From: Amanda Scholes on behalf of Planning.Responses
Sent: 02 July 2020 07:37
To: Planning Scanning
Subject: FW: Planning Consultation on M/28/20/DOC

Engineers comments;

The level of detail supplied is currently insufficient to enable the discharge of conditions 11, 13 or 14.

Site: YAPTON POULTRY FARM
Project: MIDDLETON RESIDENTIAL
Date: 01/07/2020
Drawing: SITE VISIT DISCUSSION
APPENDIX 02

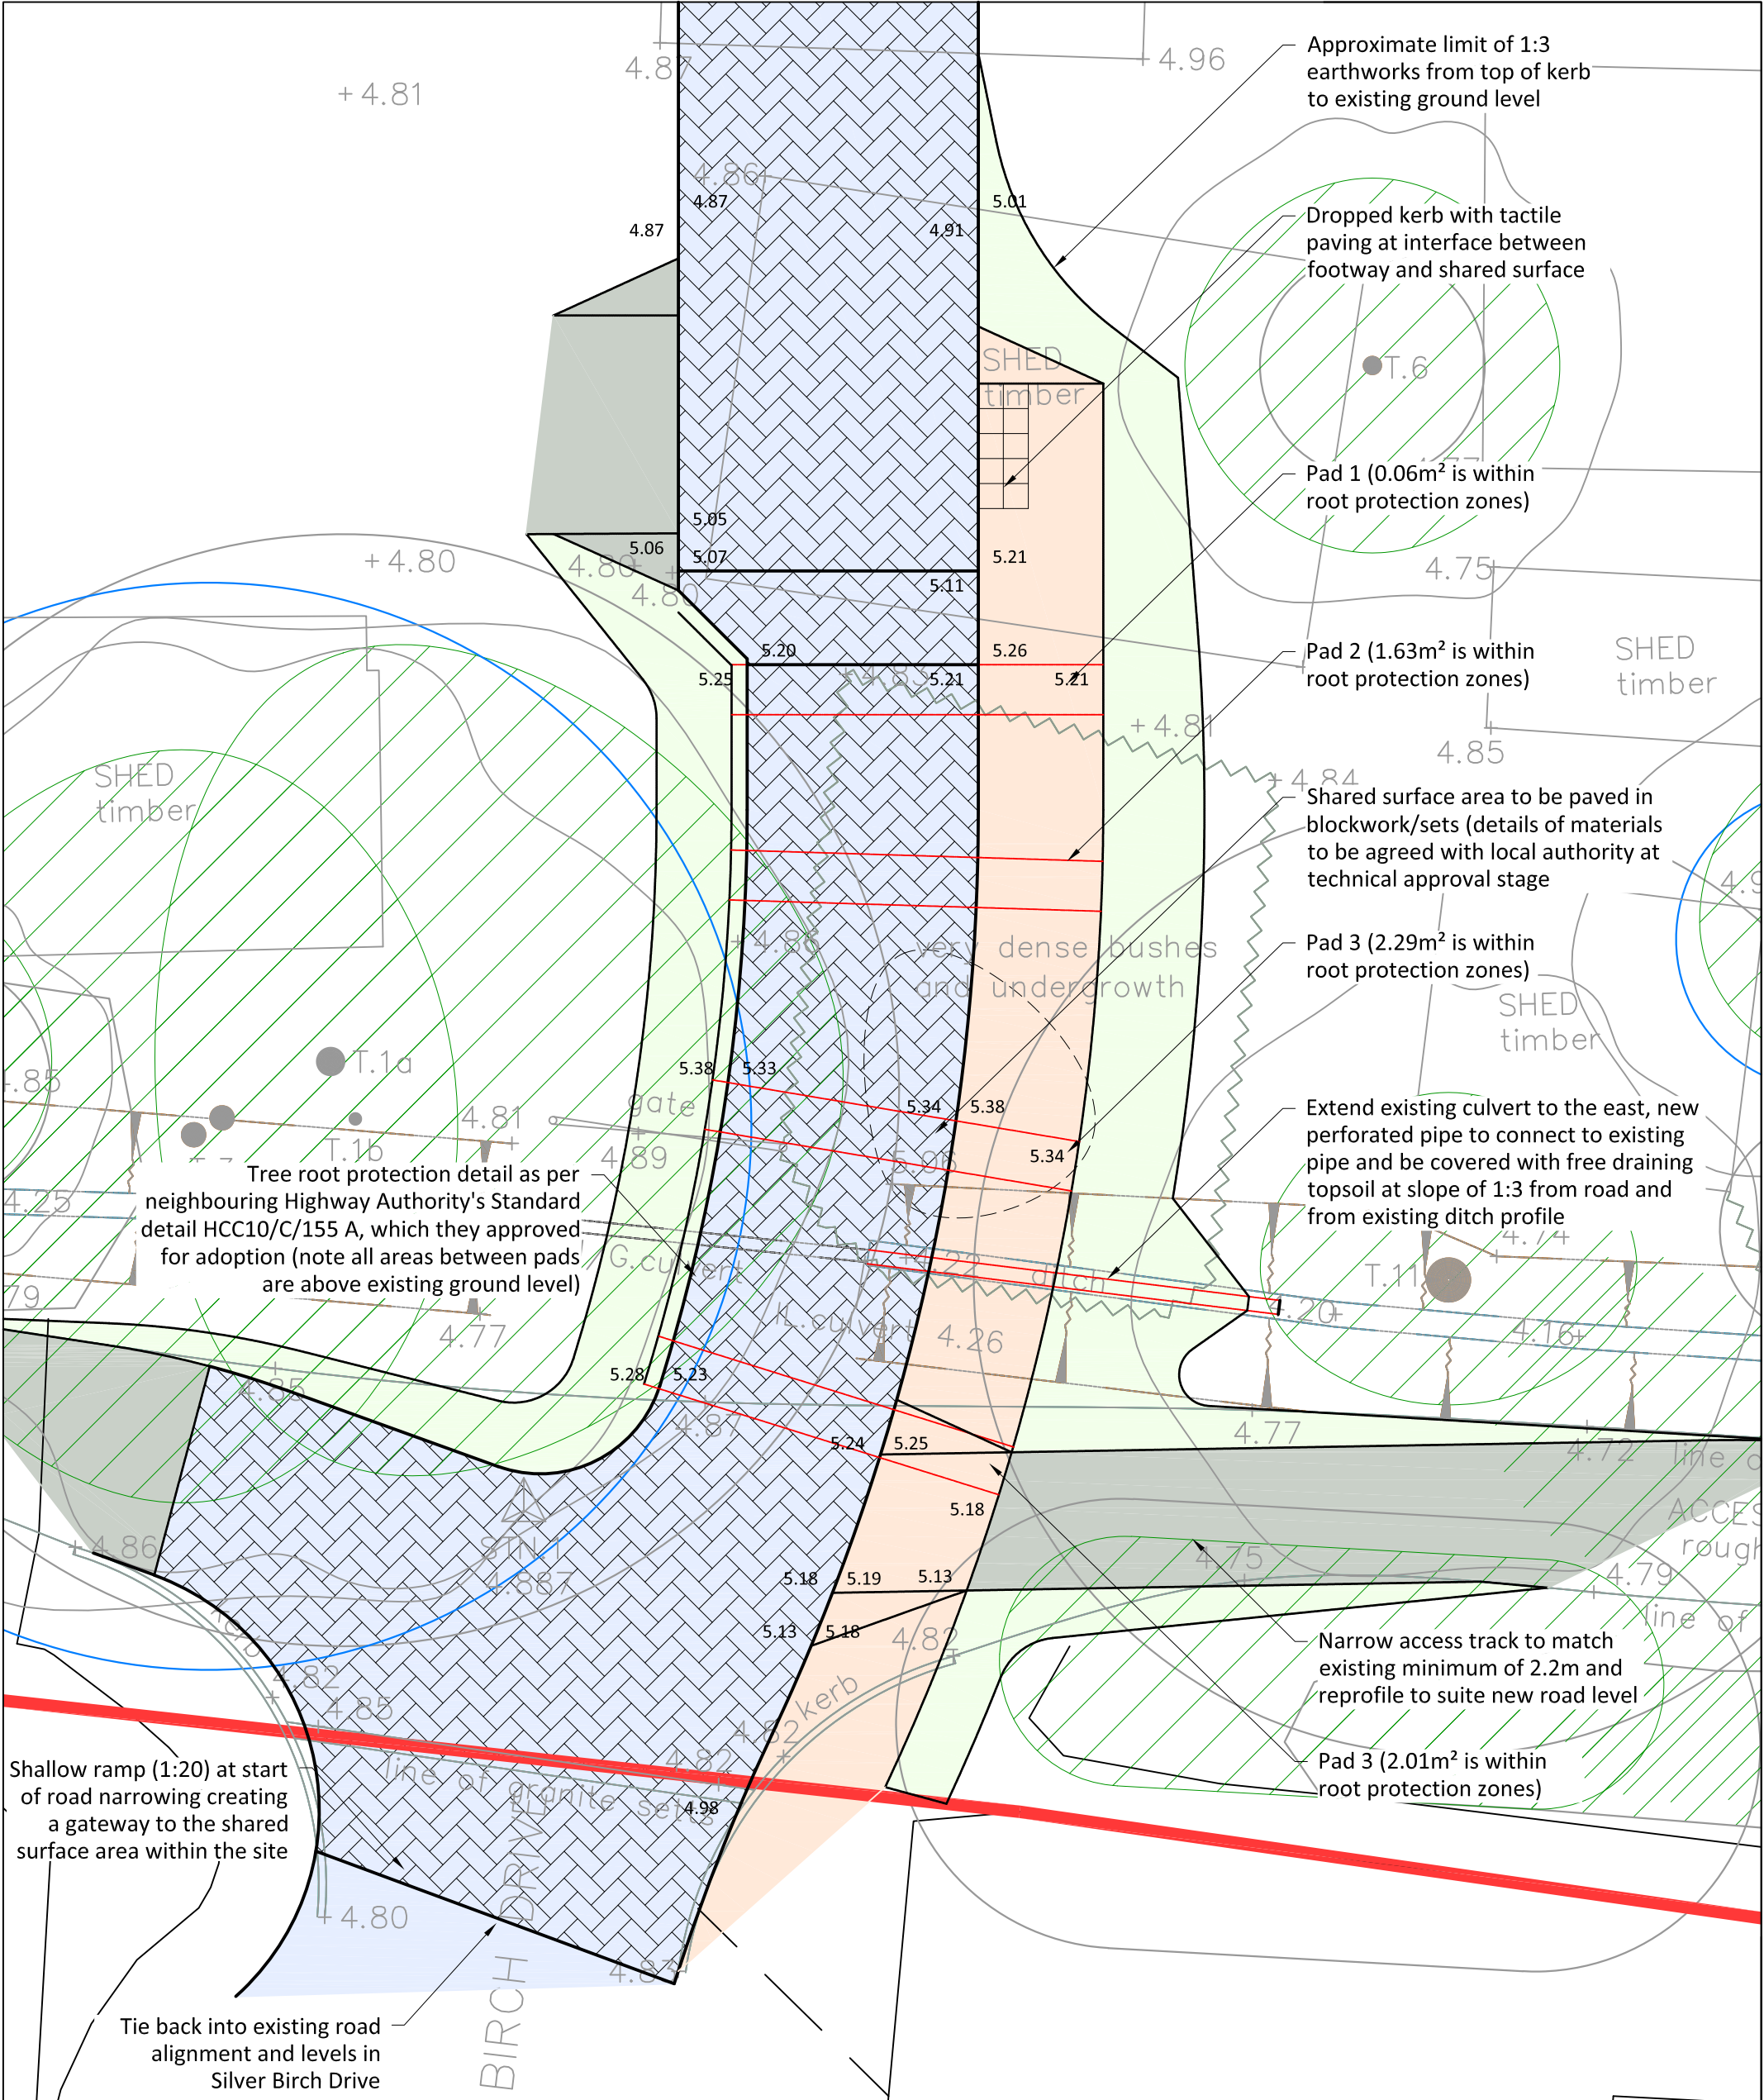
Regarding the ditches on the southern boundary, it is very likely that these will need improvements and I suggest a meeting takes place on site to look at these. Land Drainage Consent will be required for any alterations to them, including culverting and any discharge structures. This will all need to be fully detailed on the drawings.
